Our ref: NO/2022/114950/04-L01
Your ref: 3/2022/1003
Date: 06 April 2023

**DISCHARGE OF CONDITION 21 (COMPENSATORY STORAGE) FROM PLANNING PERMISSION 3/2021/0205.
LAND AT NEDDY LANE, BILLINGTON, BB7 9LL**

Environment Agency position

Pre & Post Development Floodplain
Sheet 3 of 8

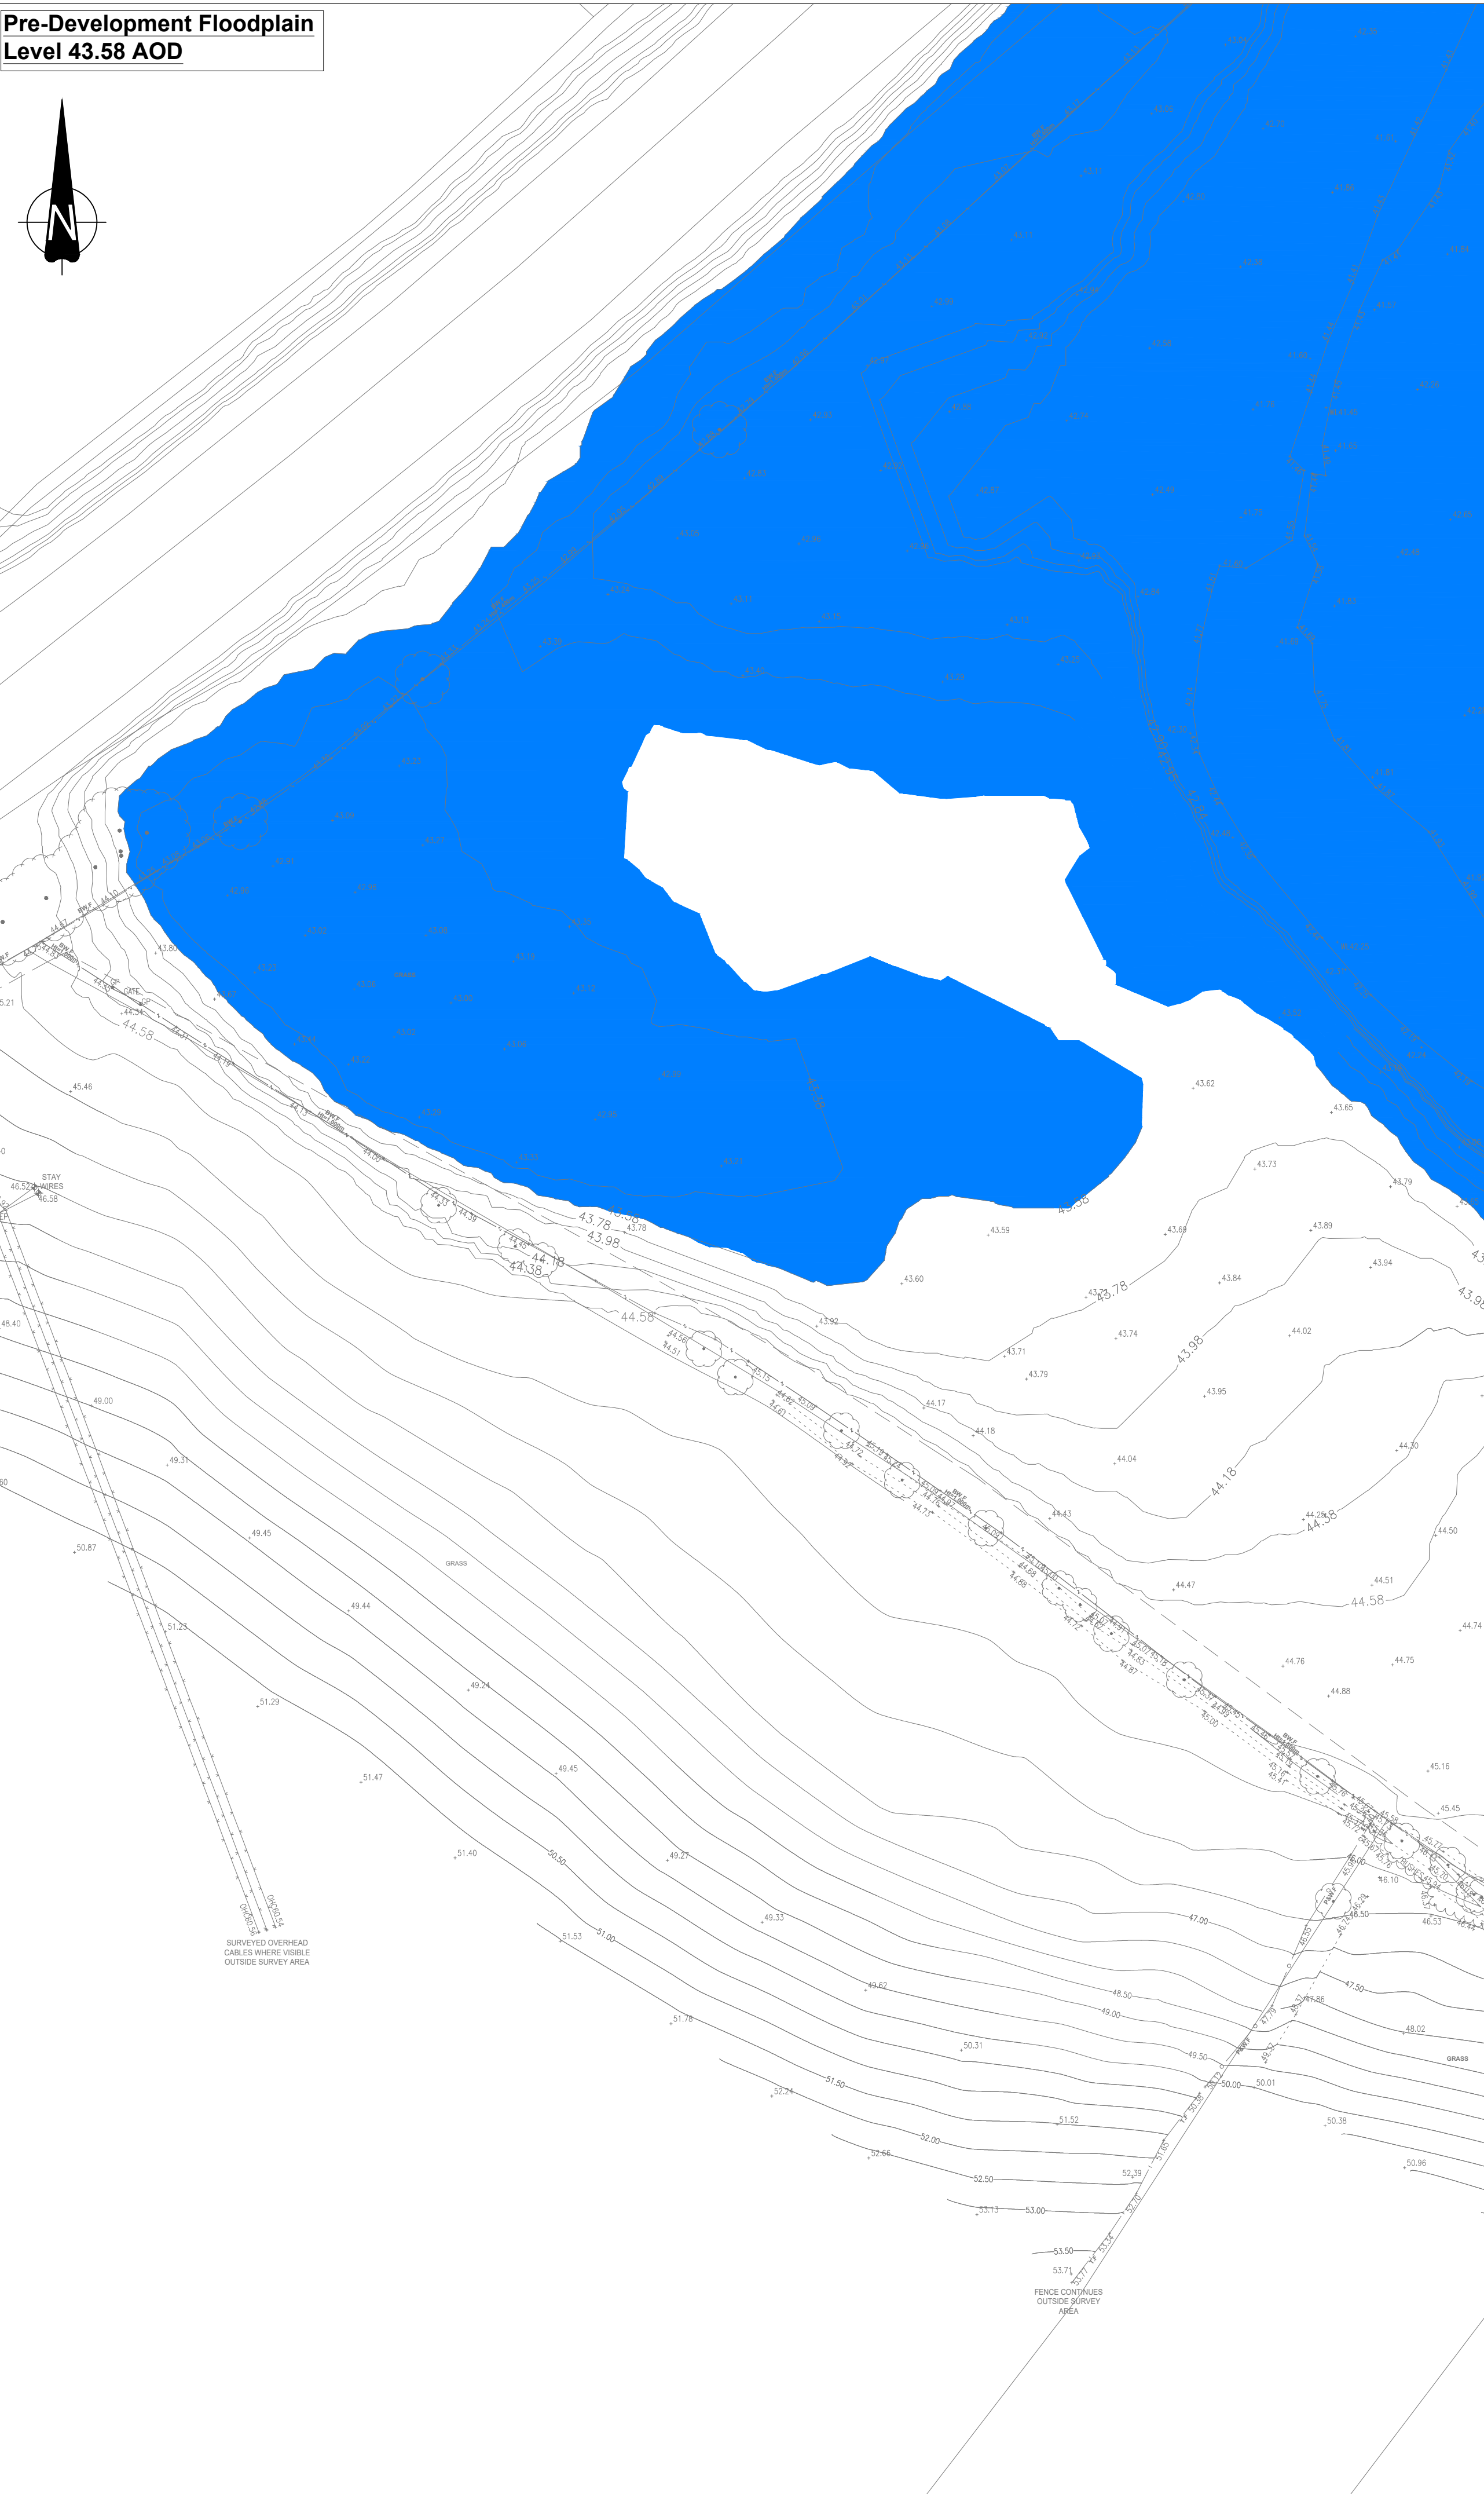
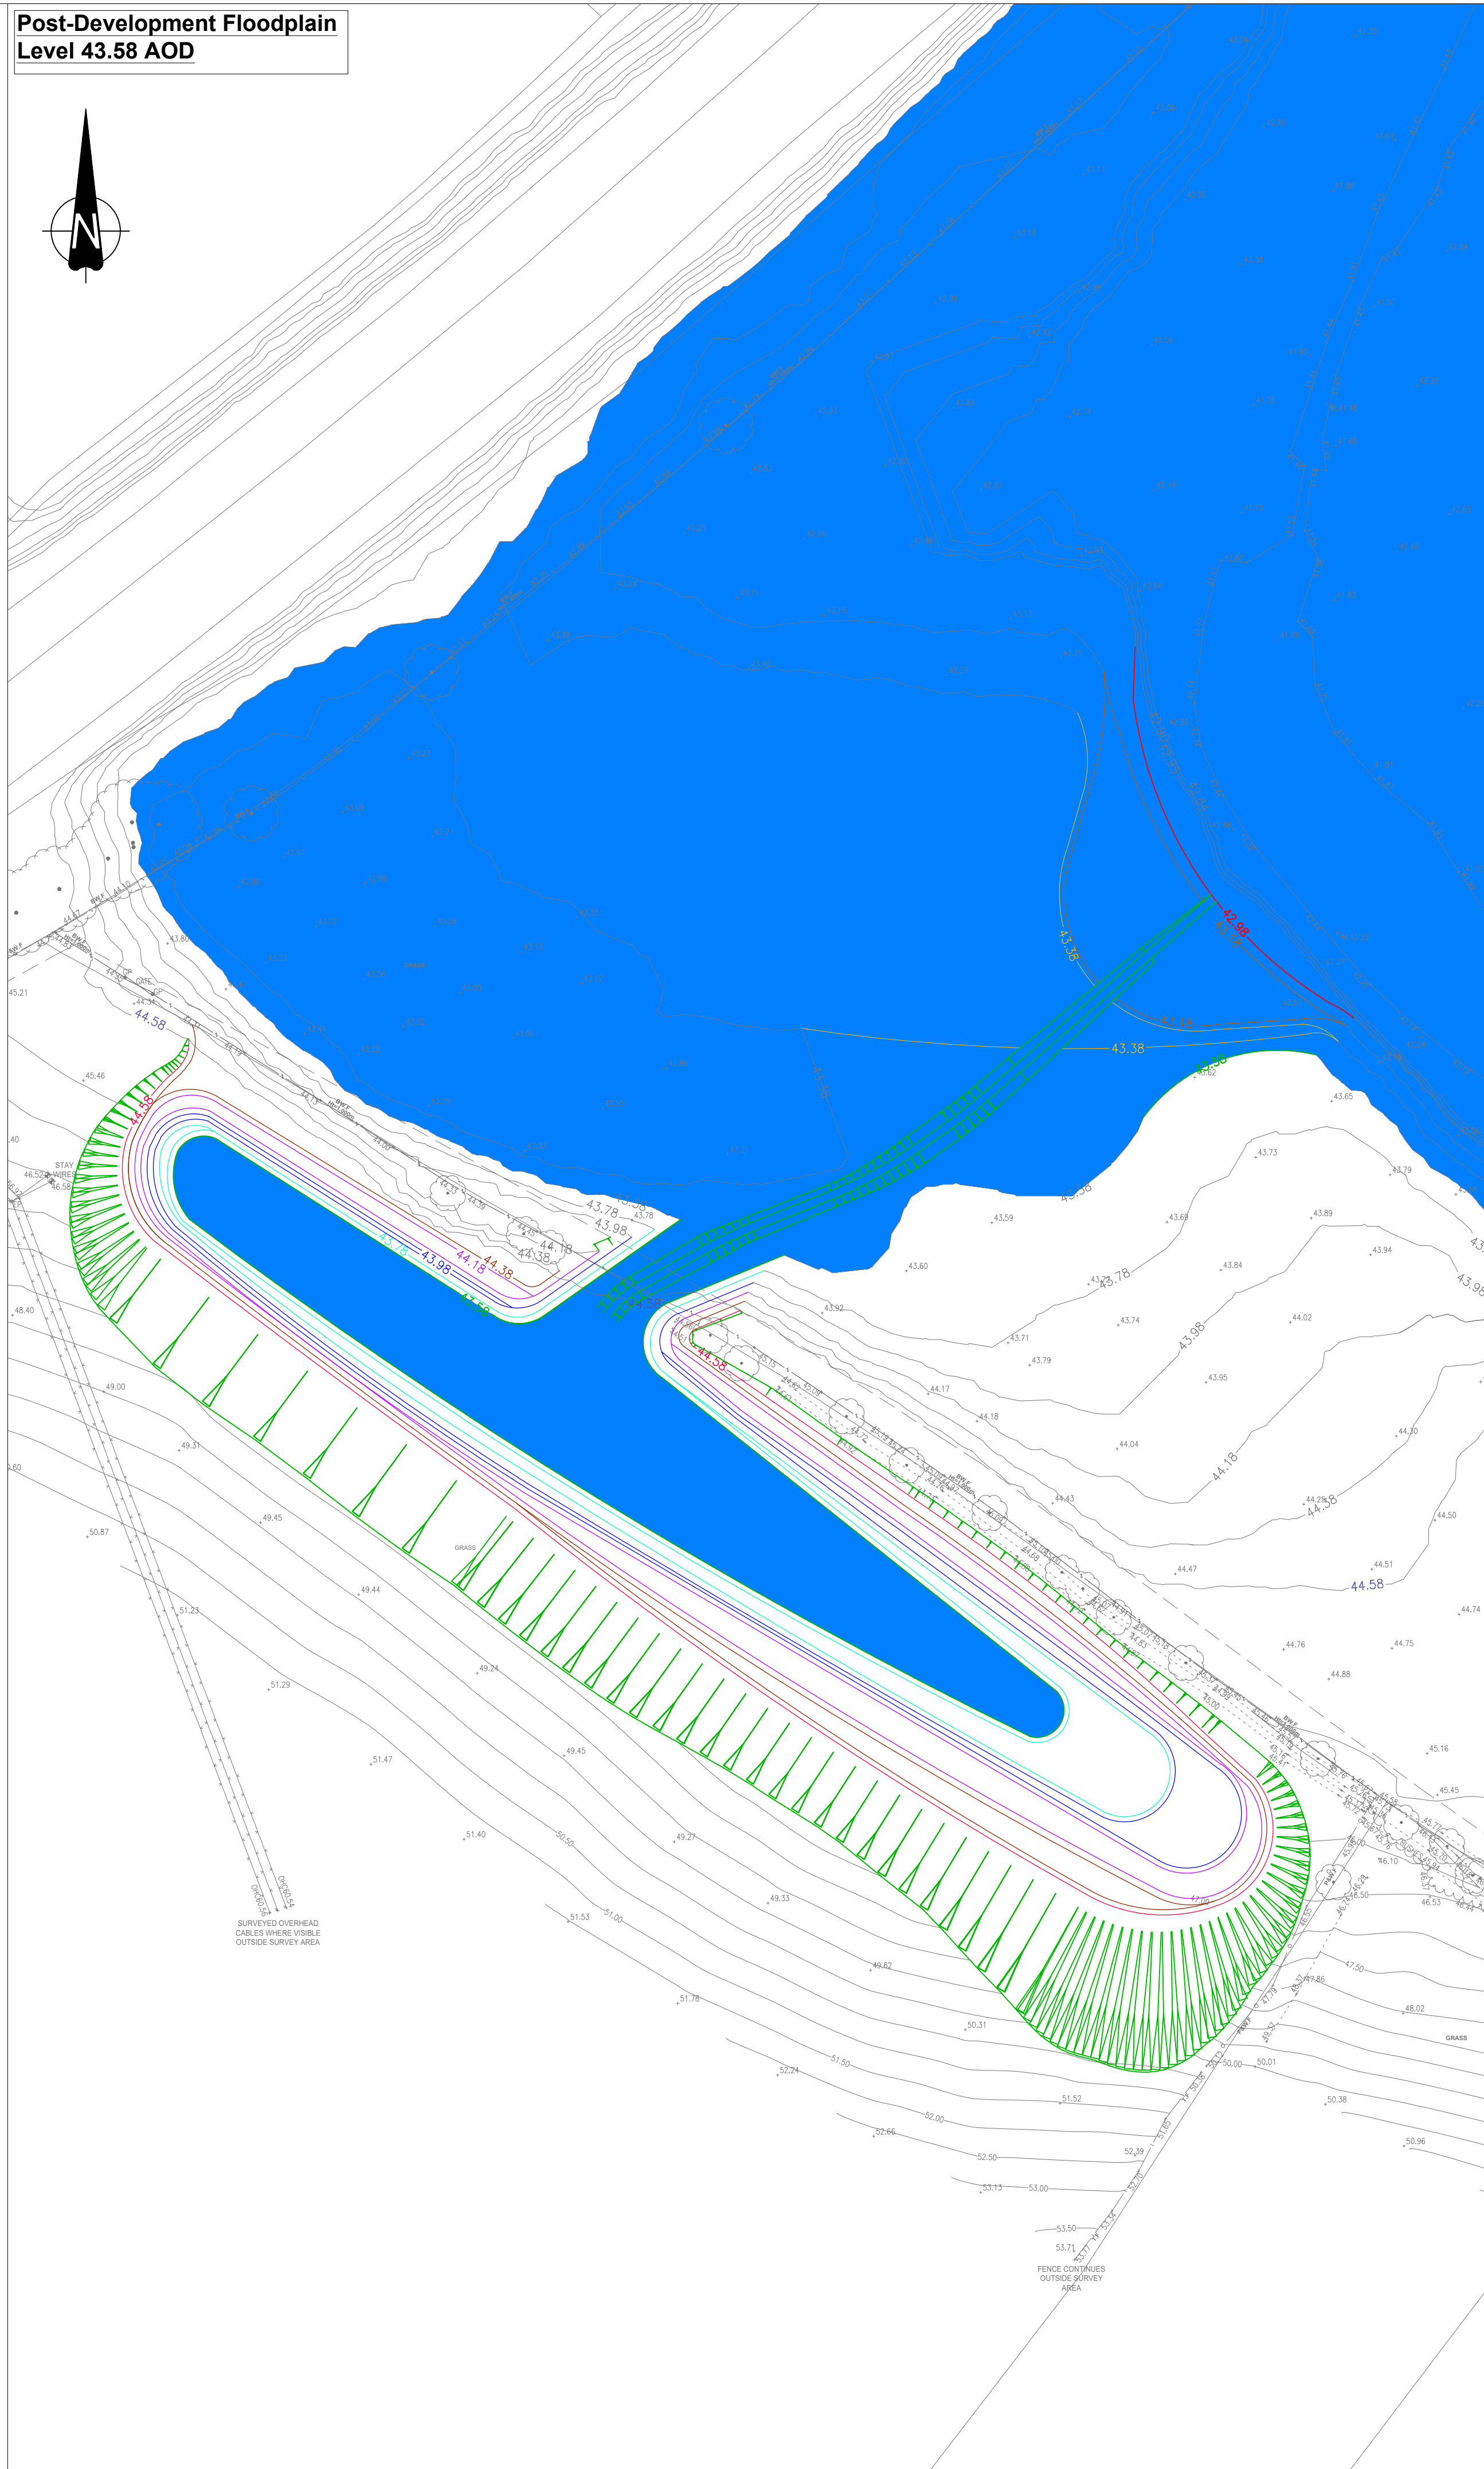
We have reviewed the details submitted to the LPA on the 21st March 23. We assume that the drawings are intended to show how flood water will propagate into the proposed flood storage area at 200mm increments to provide the required 'level for level' compensatory storage required for the proposed development platform.

The drawings do not appear to be derived from 2d hydraulic modelling, but rather an exercise in colour filling the relevant contour polylines. Therefore, we remain very concerned that the proposals are being progressed along an engineering cut and fill basis. Unfortunately, this means that there is still insufficient information regarding how the compensatory storage area will fill and drain during and after a flood event. As the submitted details do not satisfy the concerns outlined in our letter of 3 March 2023, we are currently unable to recommend the discharge of condition 21.
